PLANNING DEPARTMENT  
URBAN DESIGN & DEVELOPMENT DIVISION  
600 2nd Street NW, 3rd Floor, Albuquerque, NM 87102  
P.O. Box 1293, Albuquerque, NM 87103  
Office (505) 924-3860

## OFFICIAL NOTICE OF DECISION

**Project # PR-2020-004098**  
SI-2024-01284 – Site Plan – EPC

Interior  
Planting Plan

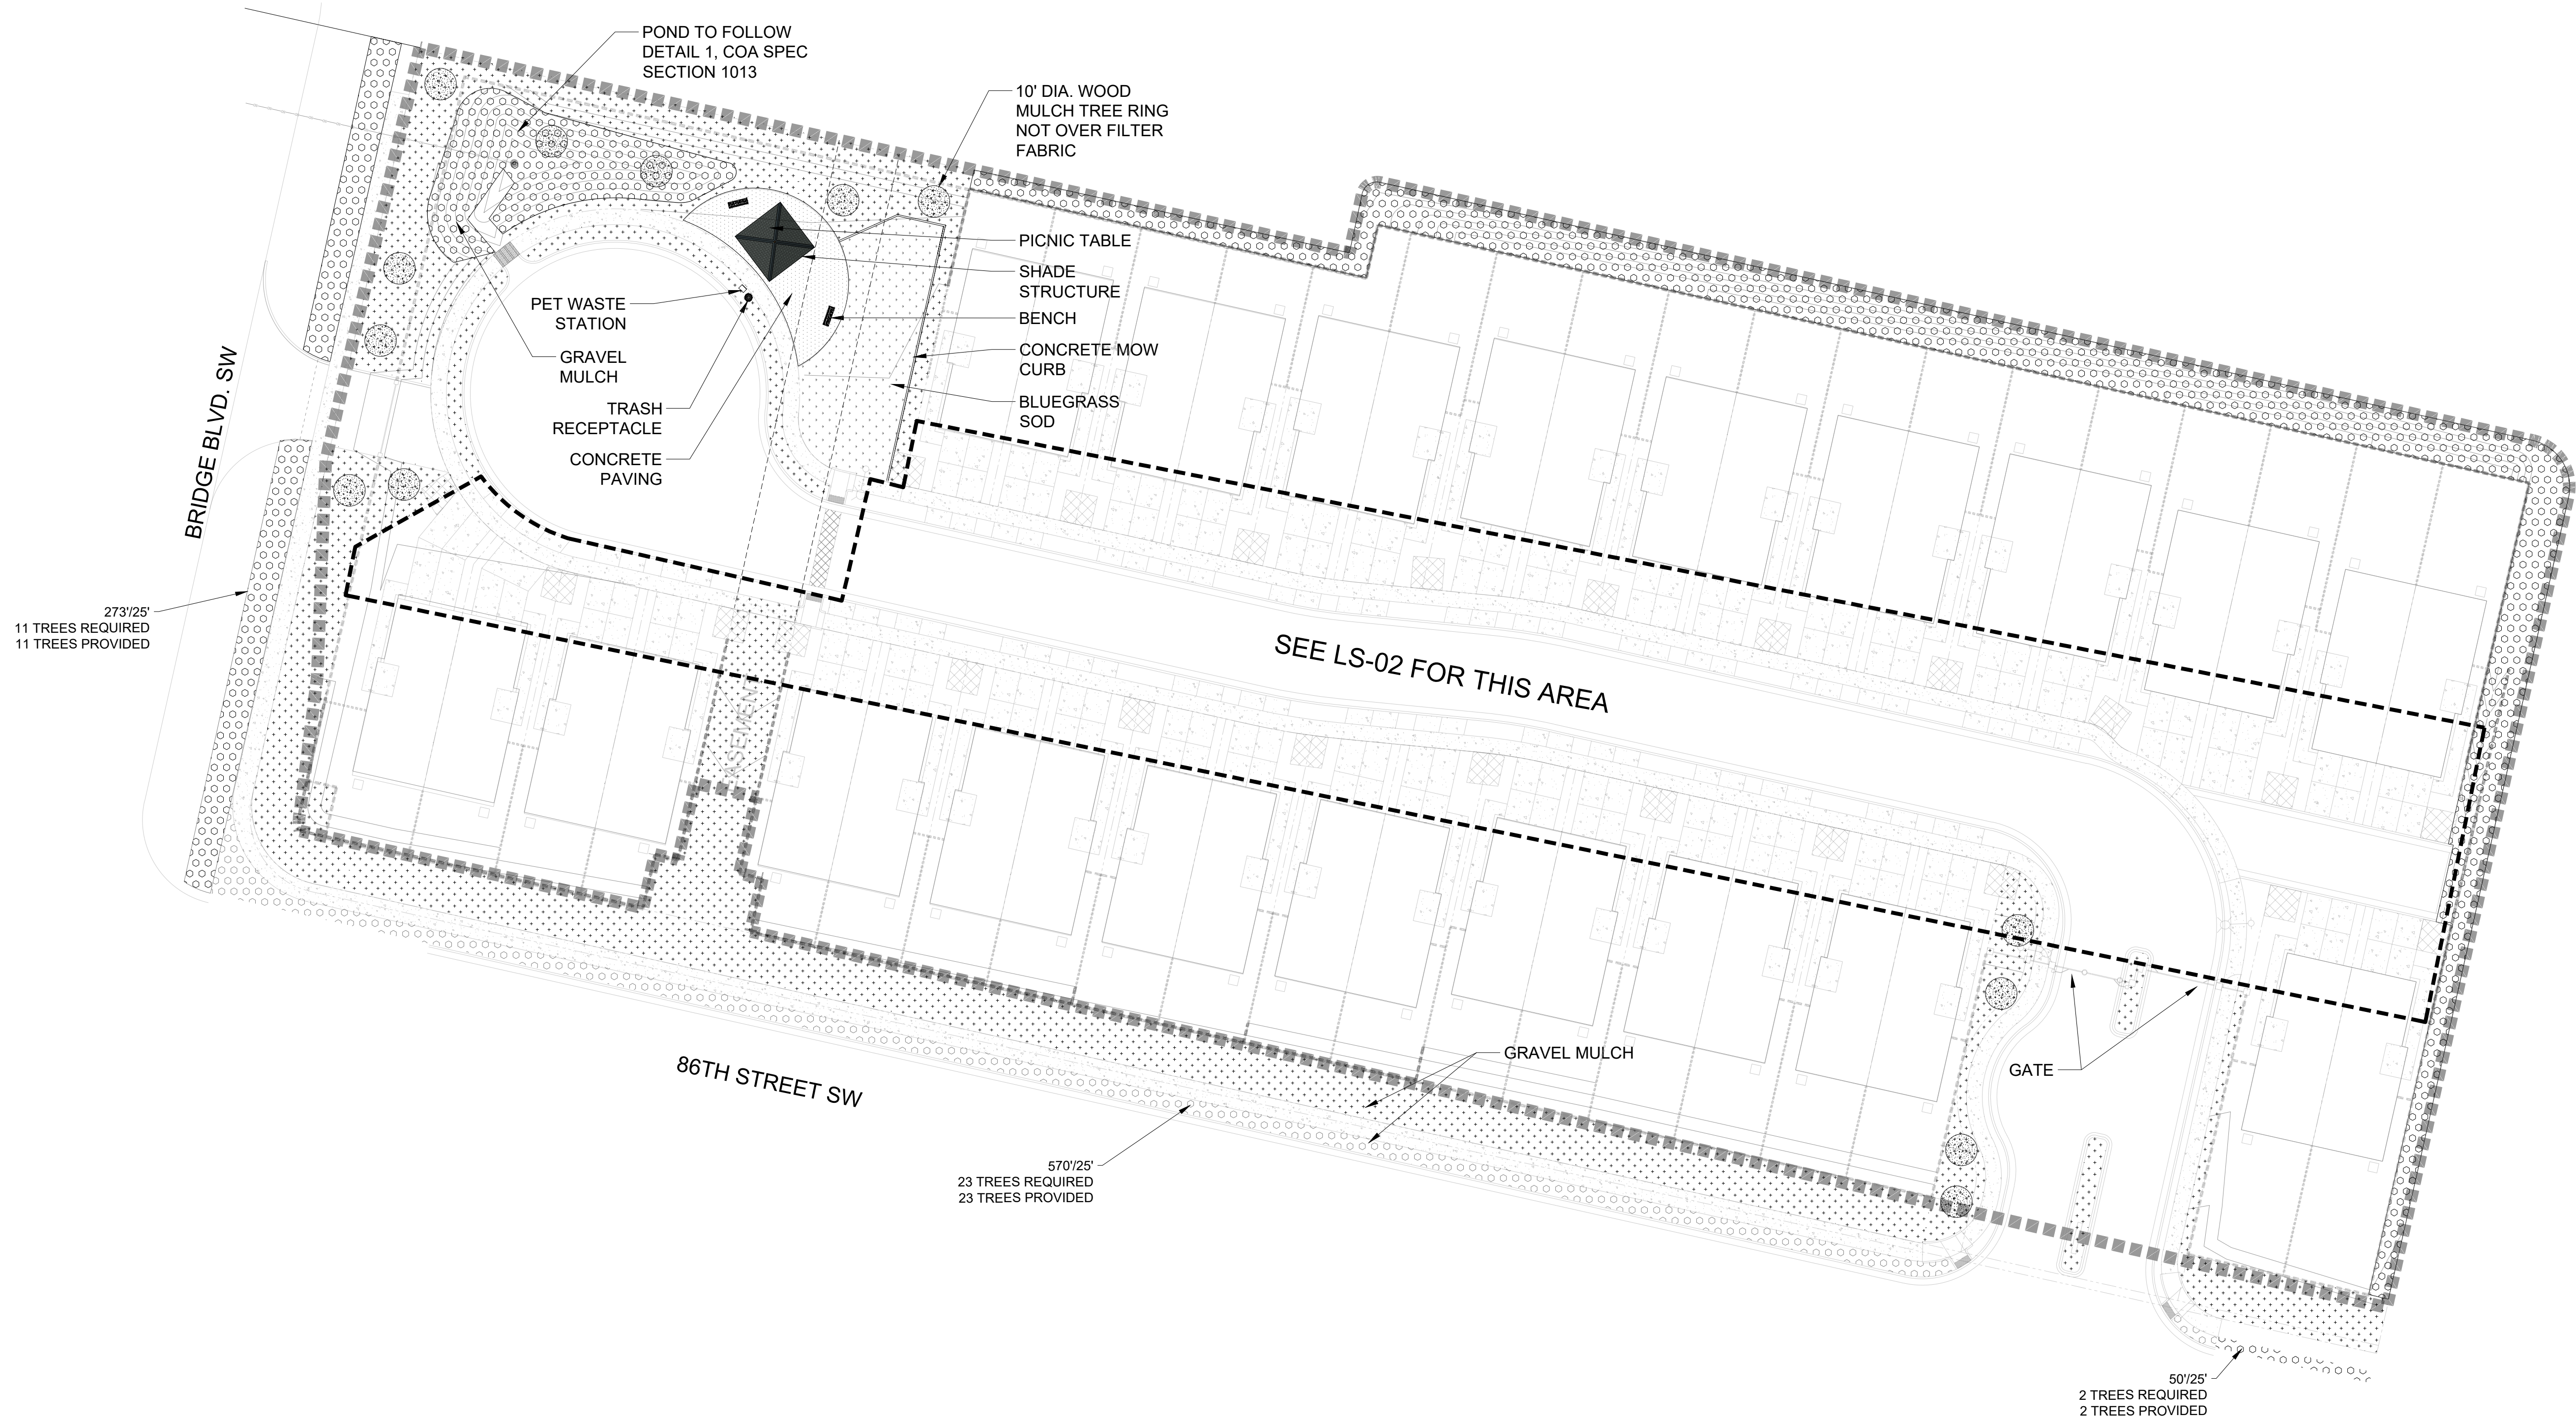
- A. Street trees shall be shown along Bridge St. SW on Landscape Plan LS-01. Per Street Tree Ordinance 6-6-2-4, street trees are required every 25' on-center for those parts of the lot abutting a major street, a major local street, or another street where street trees are required. Bridge Blvd. SW is an Urban Major Collector, and street trees are required.
- B. Pursuant to Per IDO 5-6(C)(5)(e), organic mulch shall be required as ground cover under trees, not including street trees, within a 5-foot radius around the tree trunk, but not directly against the trunk. In these areas, weed barrier fabric is prohibited.
- C. Landscape Detail #1 shall be updated to specify organic mulch. 5' radius organic mulch is required at base of street trees. If less than 5' radius is available, provide mulch as much as the space allows.

SITE PLAN

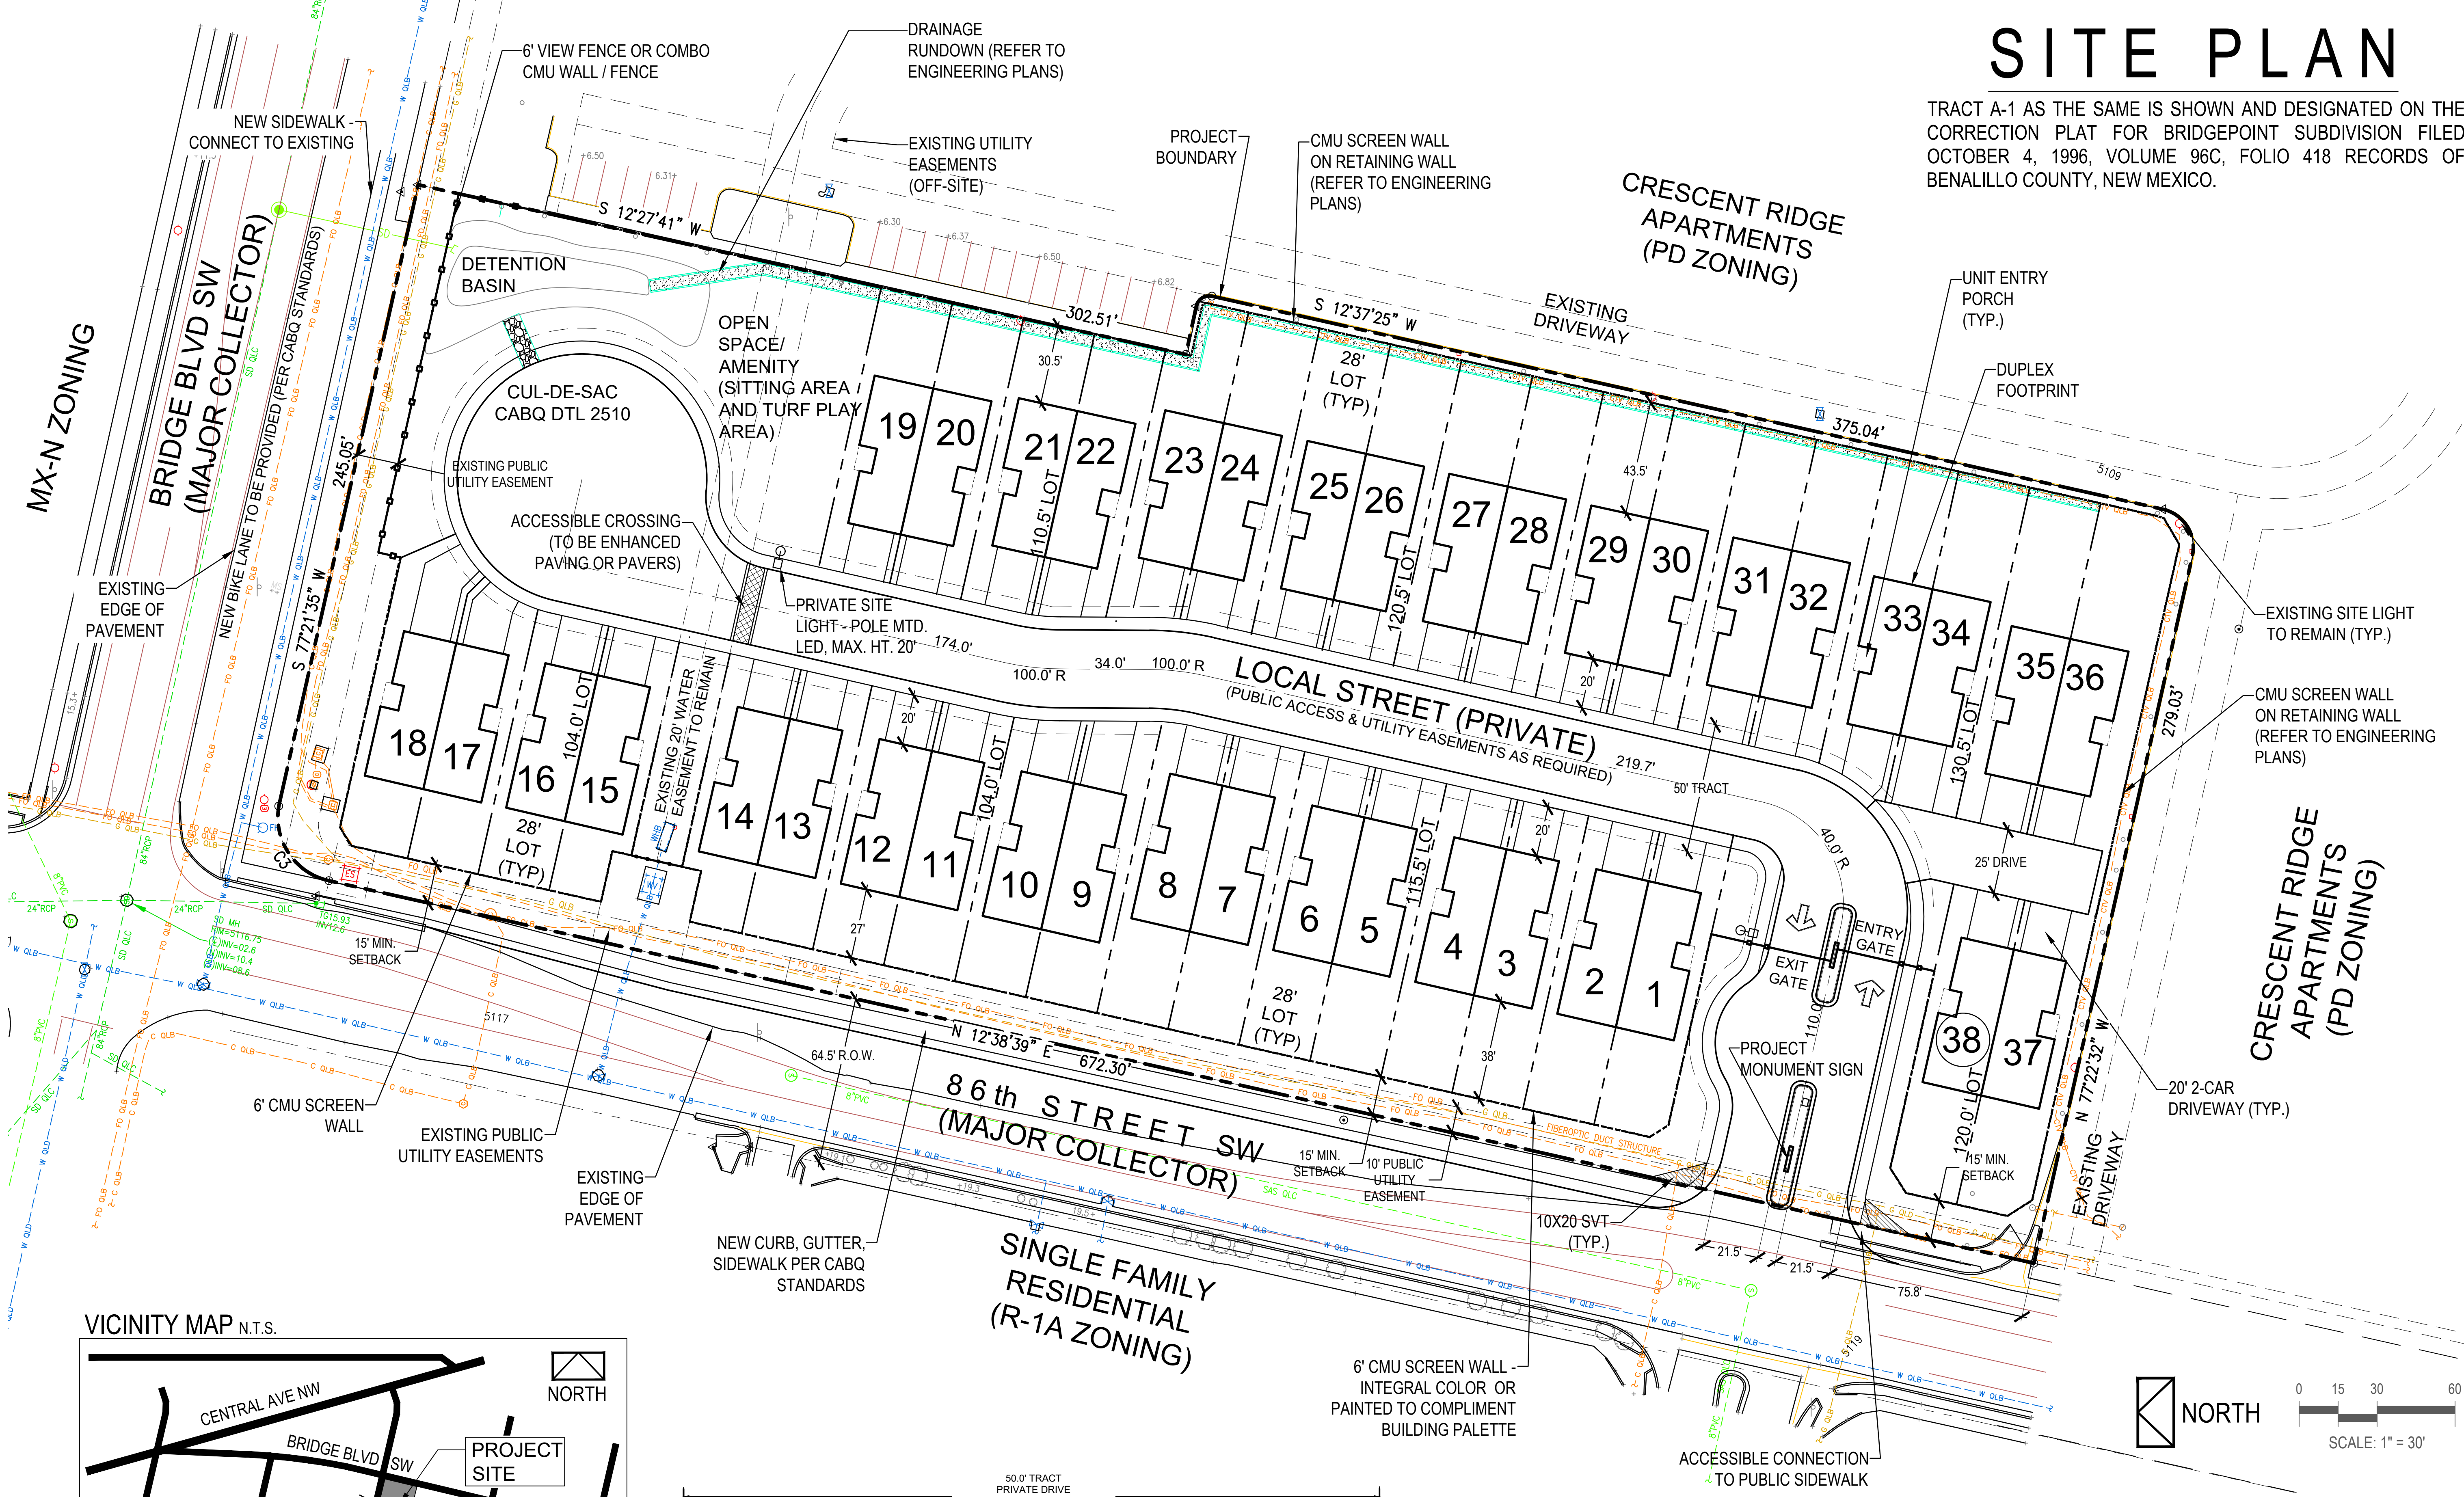
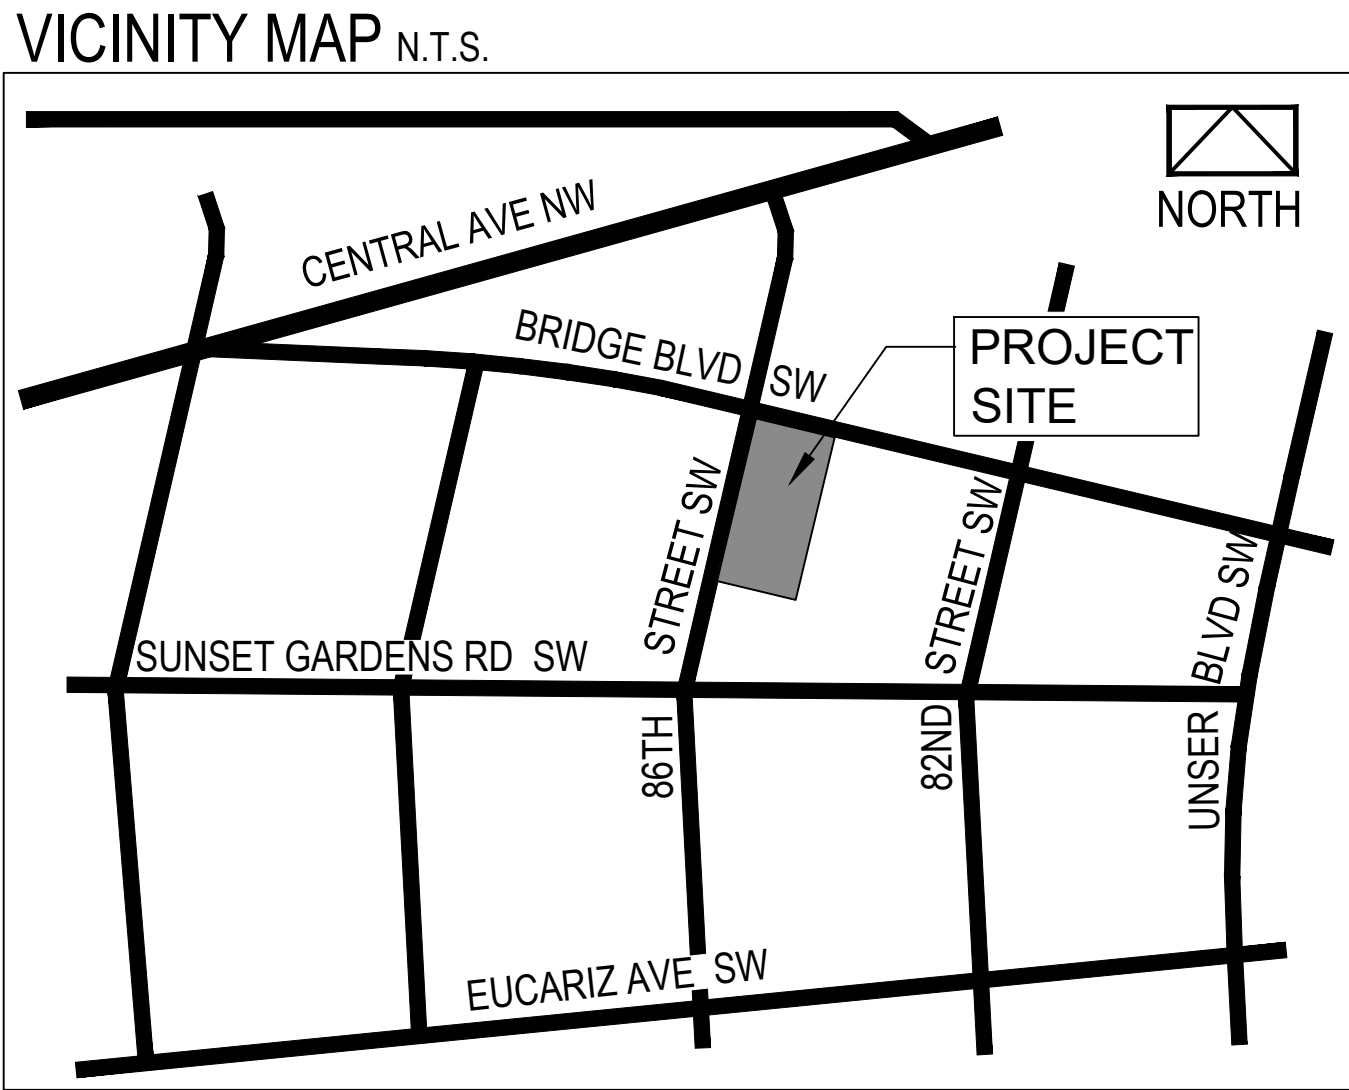
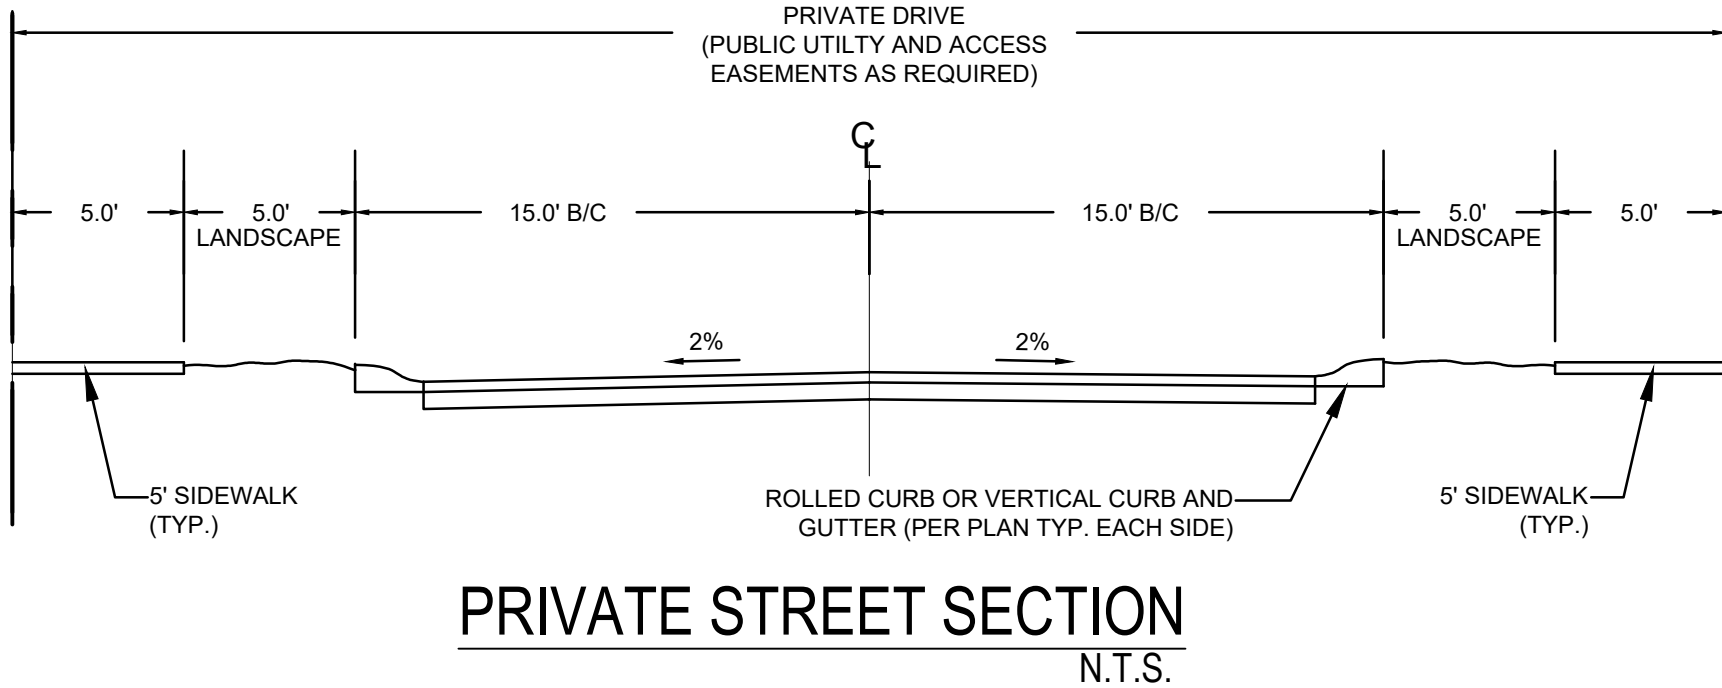
6. Site Plan:
  - A. The entry and exit gates for pedestrians/residents shall be noted.
  - B. The notation for the existing zoning for the parcel north and across Bridge Blvd SW shall be corrected from MXN to MX-M.

- C. The description “Major Collector” shall be removed from both roadways. It isn’t necessary for the site plan.
- D. The “shade trellis” on the site plan sheet shall be renamed “shade structure” to match its name on the detail sheet.

- E. The colored utilities lines shown on the site plan shall be changed to black or grey, so they are still visible, but don’t dominate the site plan drawing.

- 7. Signs:
  - A. The location of the monument sign and wall sign shall be identified on the site plan sheet.
  - B. Signage details illustrating the signage area shall be included in the drawing set, per approved plans for development in PD zoning district.
